**From:** [REDACTED]  
**To:** [Norfolk Boreas](#)  
**Subject:** Norfolk Boreas  
**Date:** 22 July 2020 09:18:13  
**Attachments:** [Bradenham Hall Farms plan.pdf](#)

Following on from the virtual meeting to discuss the proposed Norfolk Boreas sub-station at Necton on Wednesday 15<sup>th</sup> July 2020, I wish to submit my comments that were raised at that meeting.

My name is Chris Allhusen from Bradenham Hall Farms. We own the land on which the south-eastern end of the Norfolk Boreas sub-station will be constructed. This project will have a considerable detrimental effect on our Estate and farming operations, not only from a practical point of view, but also noise, visual effects and light pollution. There are nine points I wish to make.

Title:
Indicative onshore project substation mitigation planting – Scenario 2

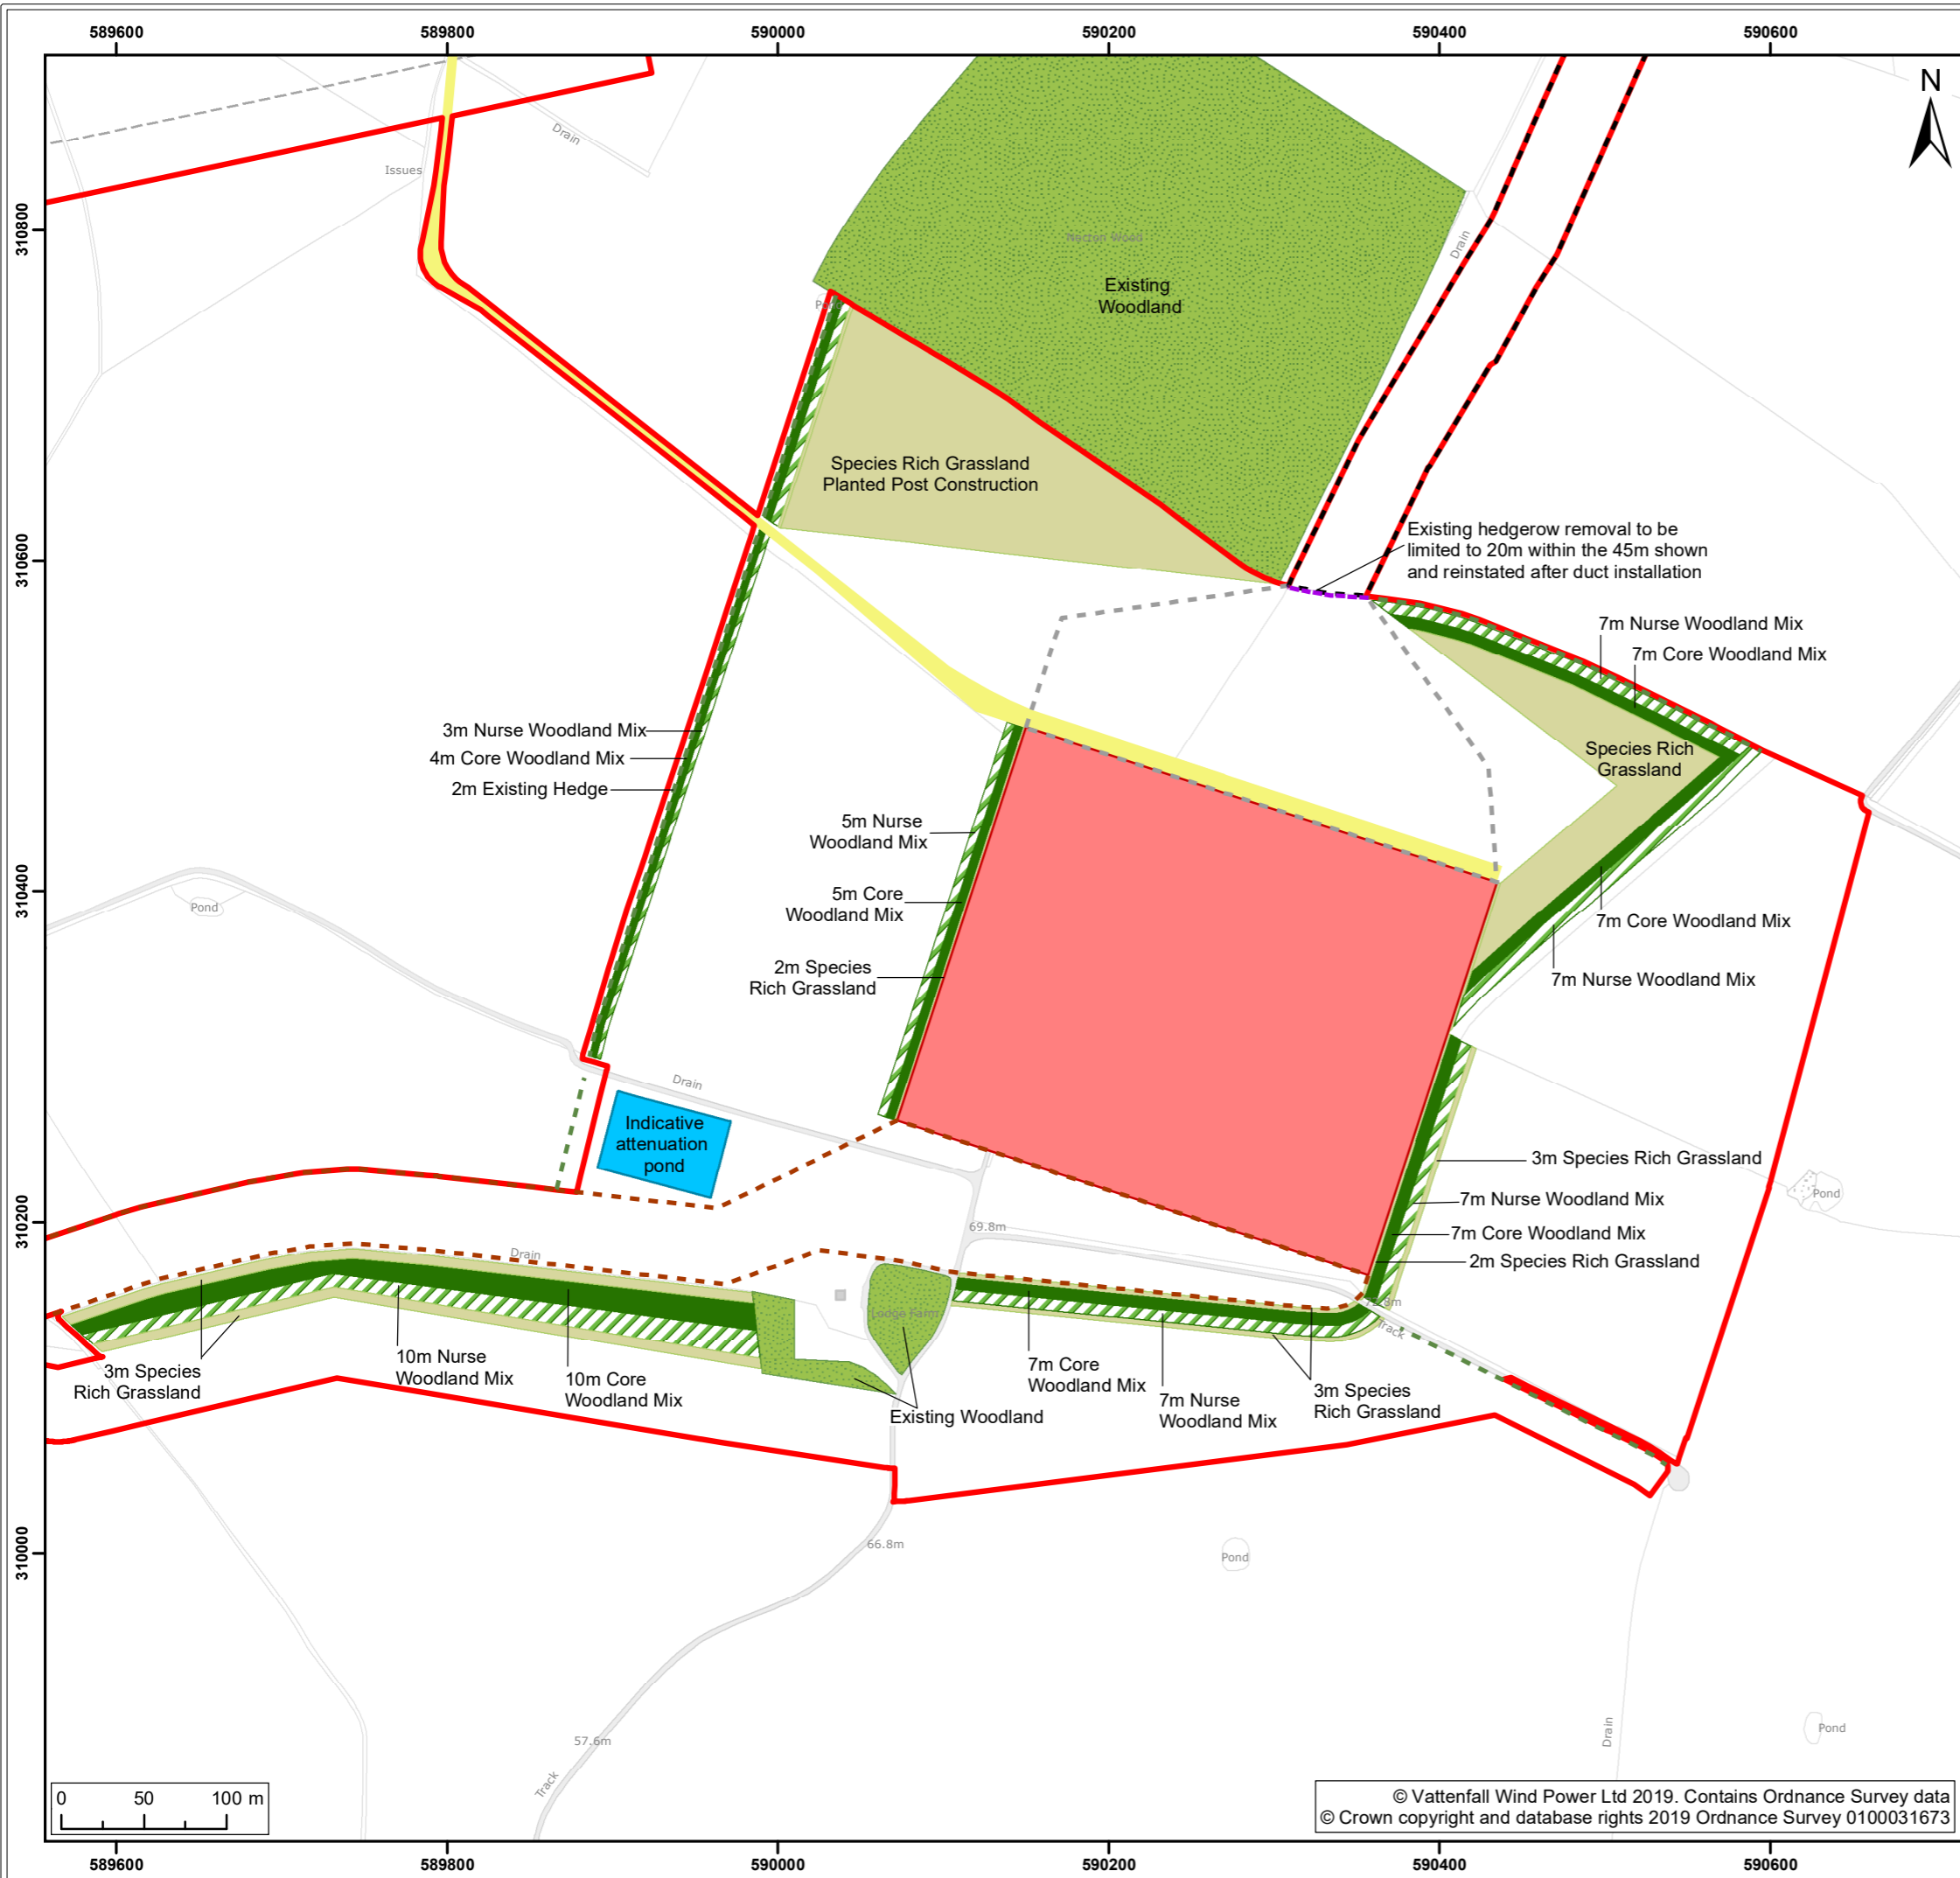
4. Bunding. The buildings could be part hidden by the use of bunding, especially on the eastern and southern sides where the land is highest, and where the buildings could be partially dug into the ground, but we are concerned that efforts to minimise local visual impact will be ignored by Norfolk Boreas as far as possible.

5. Tree screening. No trees will hide these huge buildings, and few of the trees proposed will even reach the building eaves height during the life of this project. Early planting of larger specimens and bunding could help alleviate this but so far neither project is being held to this. We have had some good discussions with Jo Phillips who is advising Norfolk Boreas, but these are

only discussions and I would like to see Norfolk Boreas commit in writing to the use of early planting and good size plants.

8. Land-locking. We requested a change to the south east corner of the site that Norfolk Boreas require in order that we are not land-locked between two fields, and can travel between them, but we have so far heard nothing definitive so far. I attach a plan showing this corner where we would ask for a 12 meter corridor (see black line indicating new boundary) to enable us to get machinery between the two fields. I have hatched in green the existing mature woodland adjacent to this corner, which is why we cannot use that area for access.
